# Rezoning Transportation Analysis

Petition Number: 2025-033

**From: Jake Carpenter, PE**

Date	Description
04-23-25	First Review (TM)
05-21-25	Second Review (TM)
07-22-25	Third Review (TM)
08-20-25	Fourth Review (TM)

RZ.01

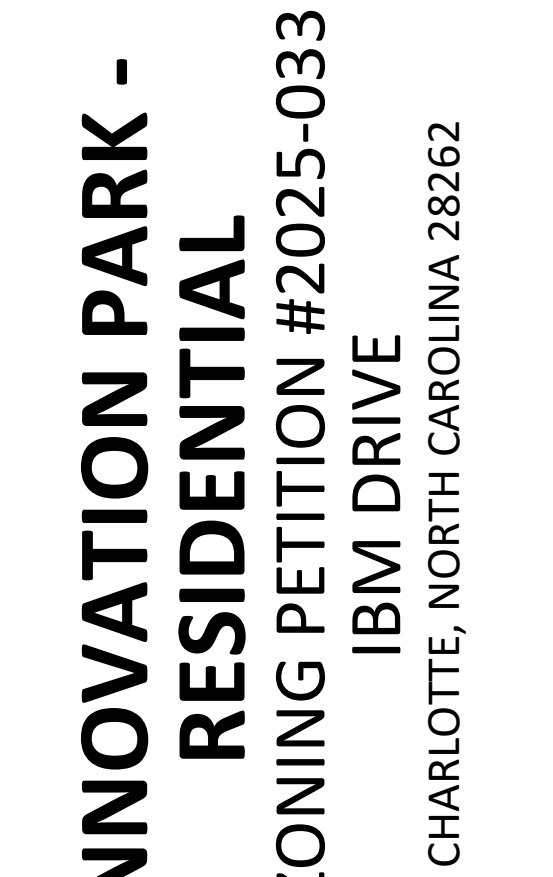
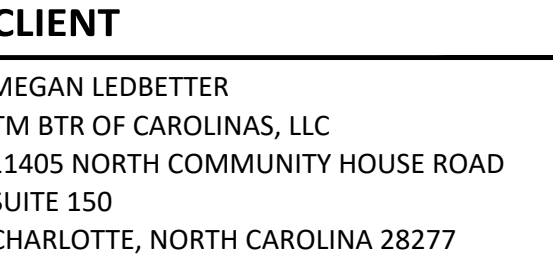
- 11. New Comment 05-21-25:** Revise site plan and conditional note(s) to minimize the jogging of the Shared-Use Path alignment. Coordinate with CDOT regarding path.
